Recommendation Report for Planning Permission for Works or Extension to a Dwelling

REF NO: WA/80/25/HH

LOCATION: Oak Bank
Wandleys Lane
Walberton
BN18 0QR

PROPOSAL: Two storey rear and single storey side extension.

PROPOSED
Site Block Plan - 1:200

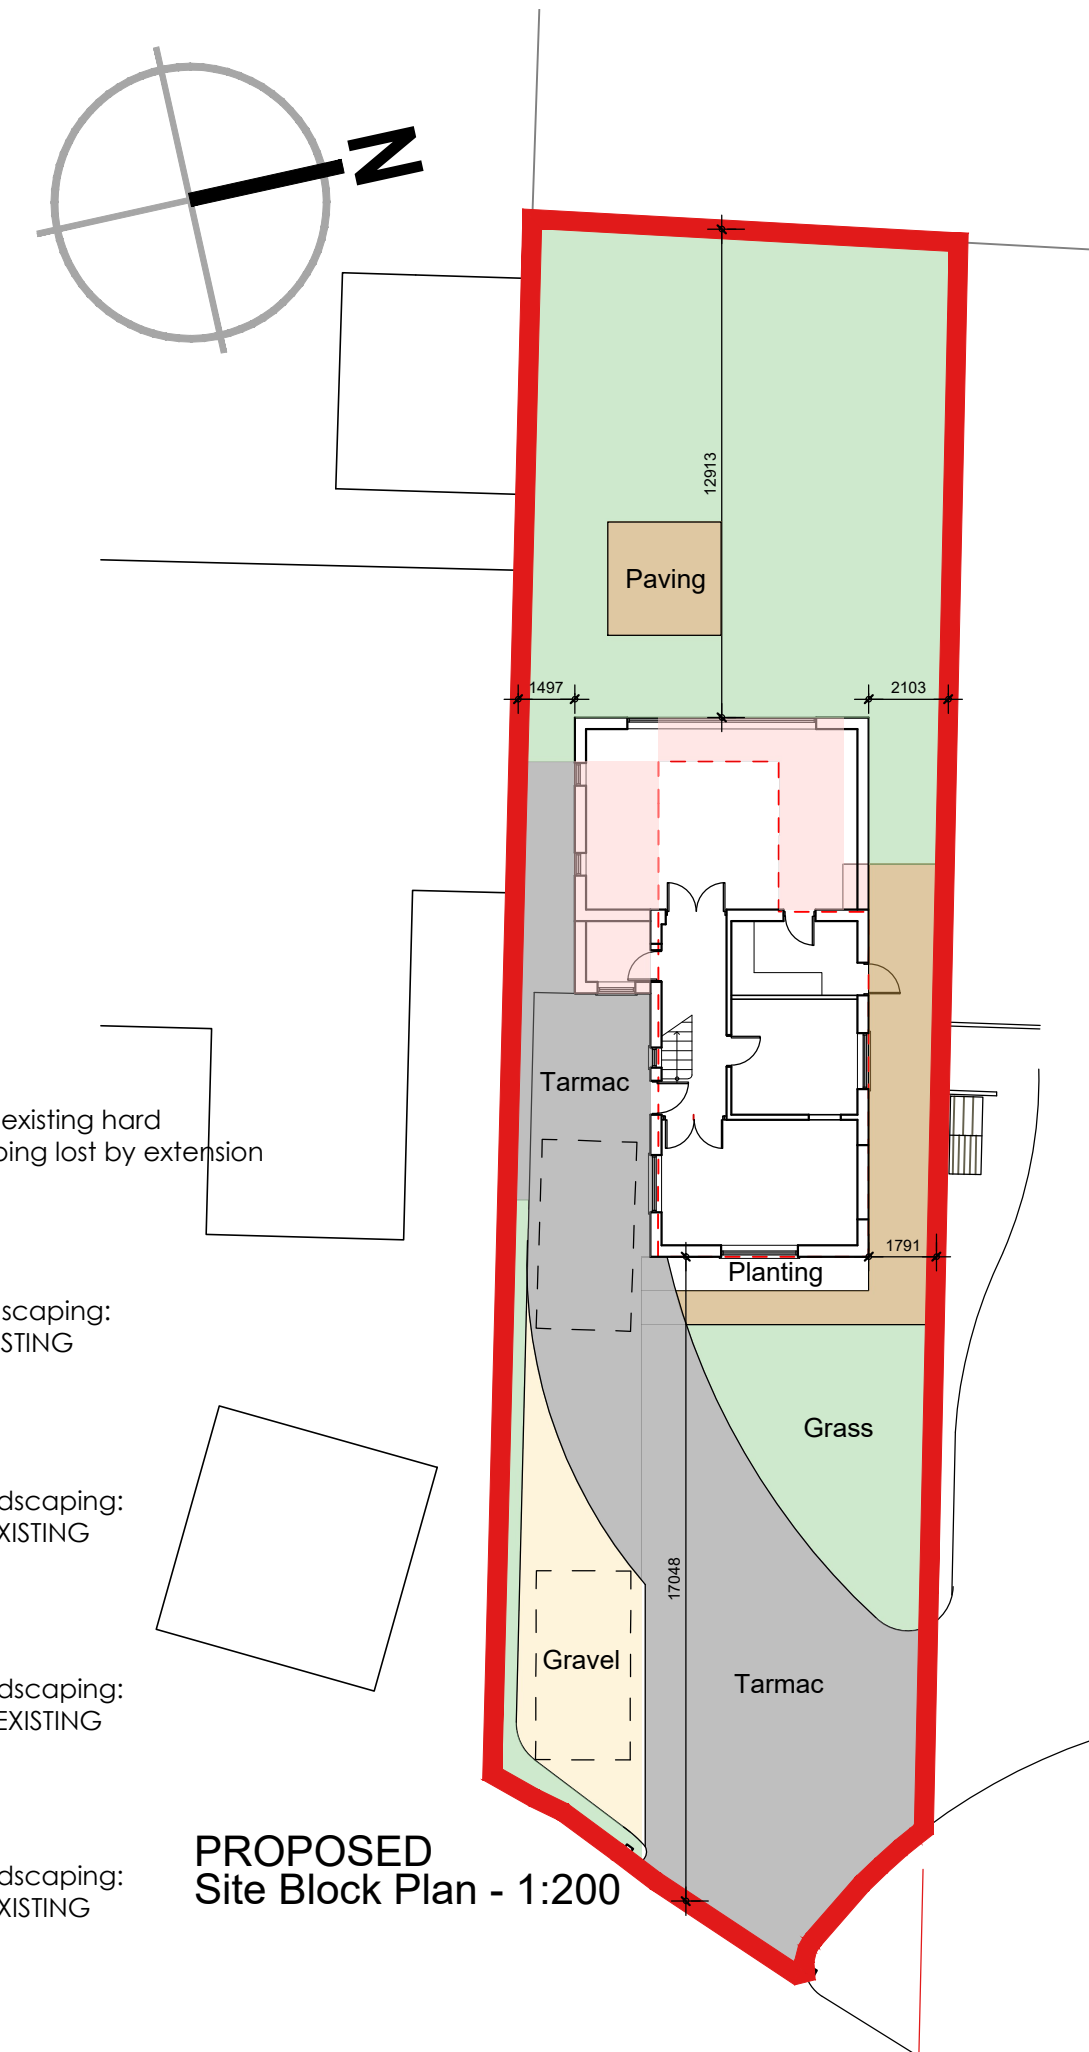
Insufficient information regarding surface water drainage has been submitted to evidence that flood risk will not be increased as due to the proposed development. No surface water drainage runoff destination has been suggested, the drive will be permeably paved. No evidence of any existing or proposed surface water drainage systems has been presented for review. It is the responsibility of the applicant or their drainage designer to provide this evidence. Without it, we are unable to assess whether the proposed development would increase flood risk. For this reason, we object to the proposal. The submission of such evidence may affect the scale and layout of the development.

The site is part of a Groundwater Source Protection Zone (2c). This should be considered by the surface water drainage design. As infiltrating to the drive is proposed, then the Environment Agency and Portsmouth Water should be consulted. It is expected that if infiltration is shallow then they are unlikely to

object. At present, no modelling or supporting evidence; such as ground investigations or drainage plans have been submitted for engineering assessment. In the absence this evidence, we cannot assess if flood risk will be increased by the surface water drainage of the proposed development. Therefore, this application does not accord with the NPPF as set out above.

The proposed extensions would partly replace an existing structure to the rear, and the majority of the extensions would extend over existing hardstanding. It is noted that a minor part of the rear extension would extend over existing grass, however given that the vast majority of the proposed development would extend over existing hardstanding, it would not be reasonable to refuse planning permission in this instance. An informative is attached to the planning consent outlining appropriate drainage interception features for the scale of the development.

Given that the proposed extensions would extend over an area which currently partly comprises hardstanding, a refusal on drainage grounds would not be reasonable in this instance. The proposals would not increase flood risk elsewhere, in accordance with policies W DM1 and W DM3 of the ALP.

- 4 INFORMATIVE: The applicant is advised that drainage interception features are to be provided where possible to make a positive contribution to reduce surface water. In recognition that the National Planning Policy Framework states that SuDS should be proportionate to the nature and scale of the proposal, the following interception features can demonstrate compliance without further detailed assessment:

- Infiltration features designed to meet extreme rainfall standards.
- Water butts or other means of reuse that are not designed for regular daily demand attached to all new downpipes.
- Raingardens and bioretention features attached to all new downpipes.
- Permeable surfacing.
